PROJECT NO. <u>100 2222</u>	APPLICATION NO. <u>02 DRB - 01419</u>
PROJECT NAME <u>SIESTA HILLS #2</u>	
APPLICANT / AGENT <u>Jim Wilks</u>	PHONE NO. <u>888 - 3066</u>
ZONE ATLAS PAGE <u>M-18</u>	DATE SUBMITTED <u>10-8-02</u>

DRB CASE ACTION LOG

Project Name: SIESTA HILLS SUBDIVISION #2

DEVELOPMENT REVIEW BOARD--SPEED MEMO

PLAT OF
TRACTS G-2-A-1 AND H-2-A-1
SIESTA HILLS SUBDIVISION No. 2
 WITHIN
 SECTION 36, TOWNSHIP 10 NORTH, RANGE 3 EAST, N.M.P.M.
 CITY OF ALBUQUERQUE
 BERNALILLO COUNTY, NEW MEXICO
 AUGUST, 2002

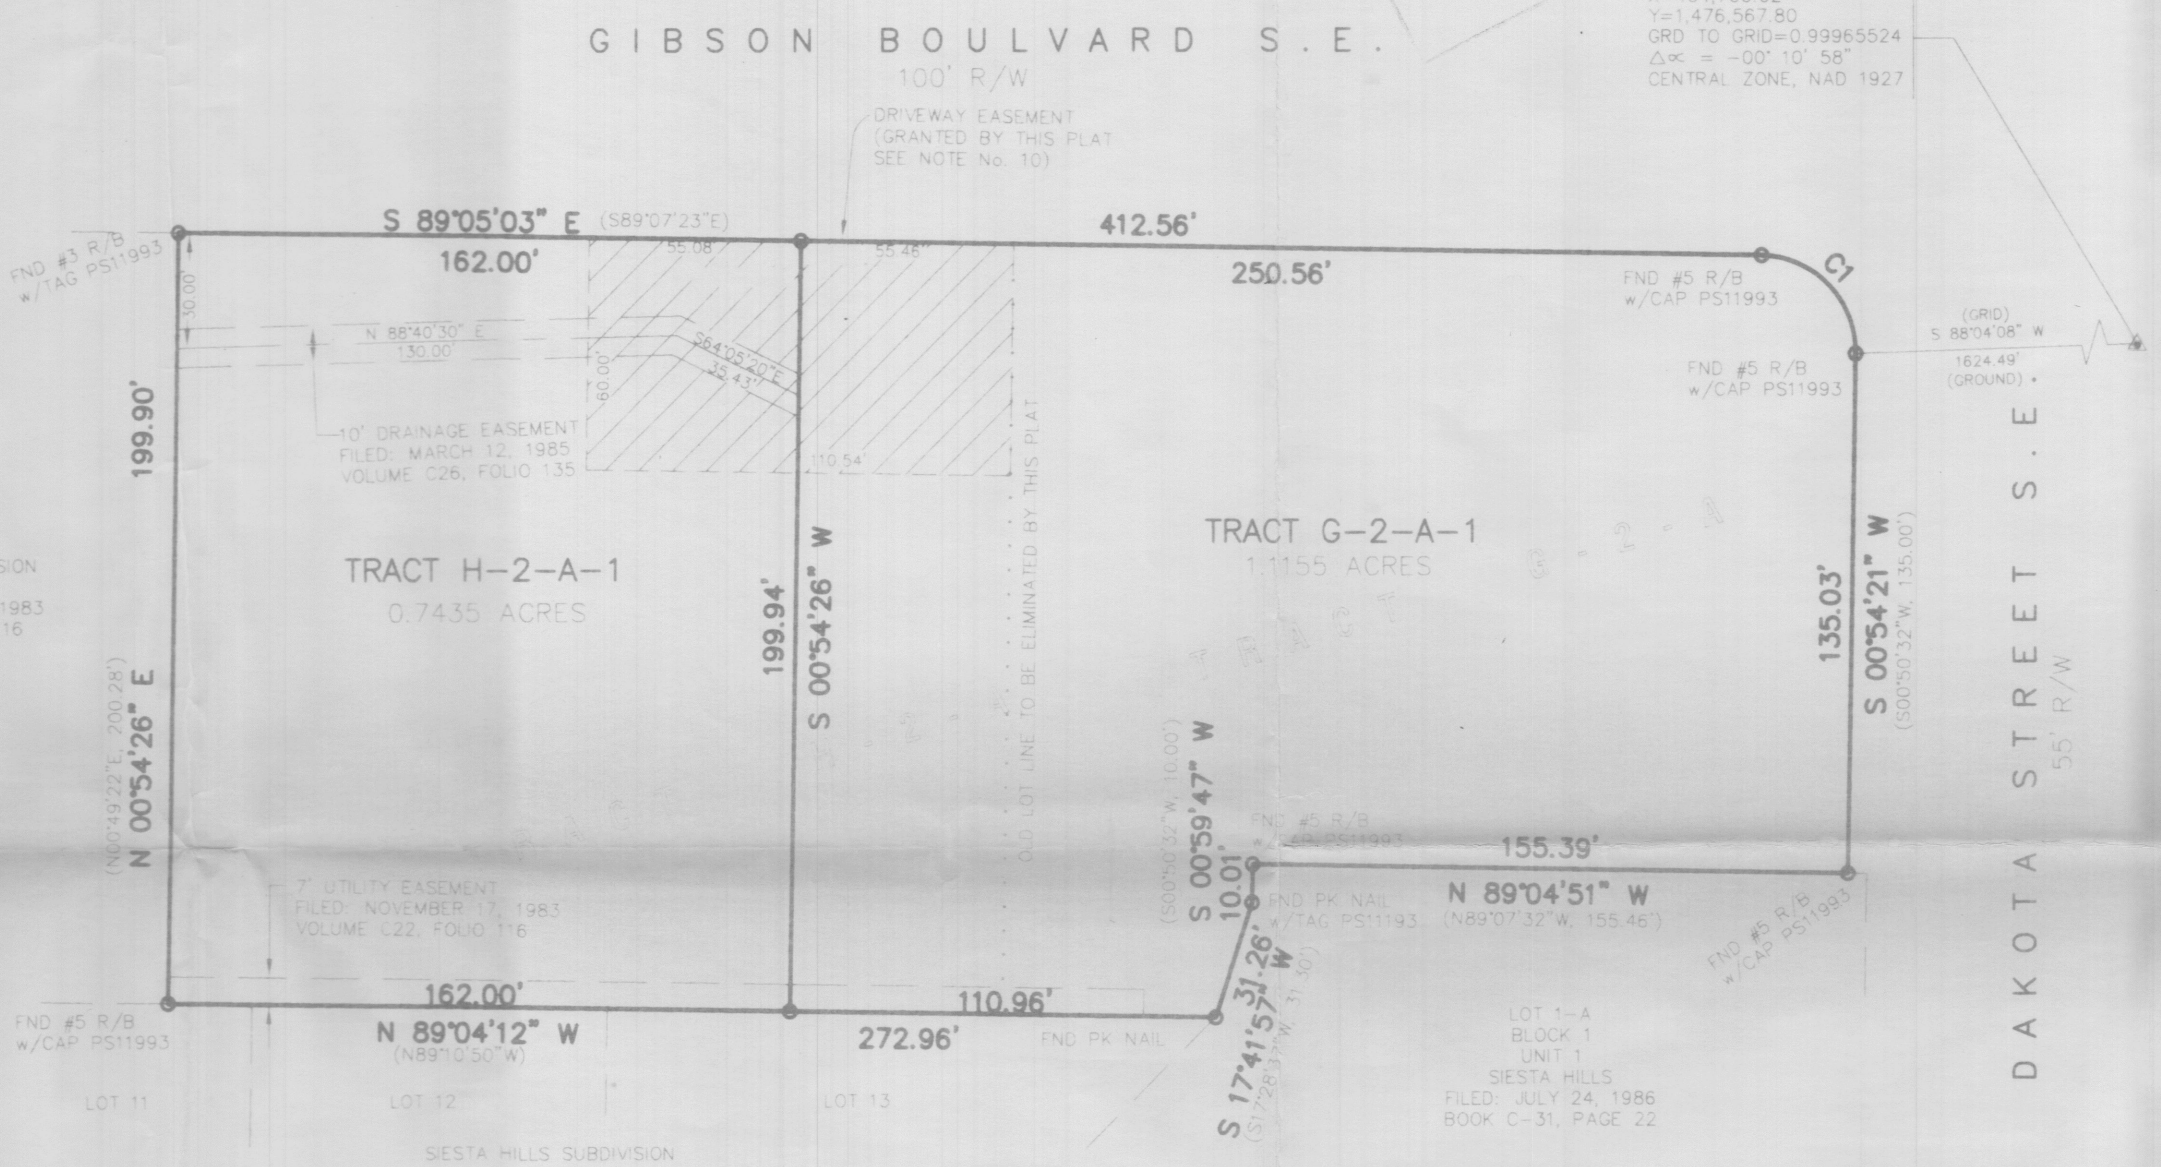
TRANSPORTATION: Site sketch is needed -

CITY ENGINEER / AMAFCA:
 Purpose of drainage easement to actual extents

What is the purpose of the drainage easement and why would it have stopped at the proposed lot line? Please provide original document.
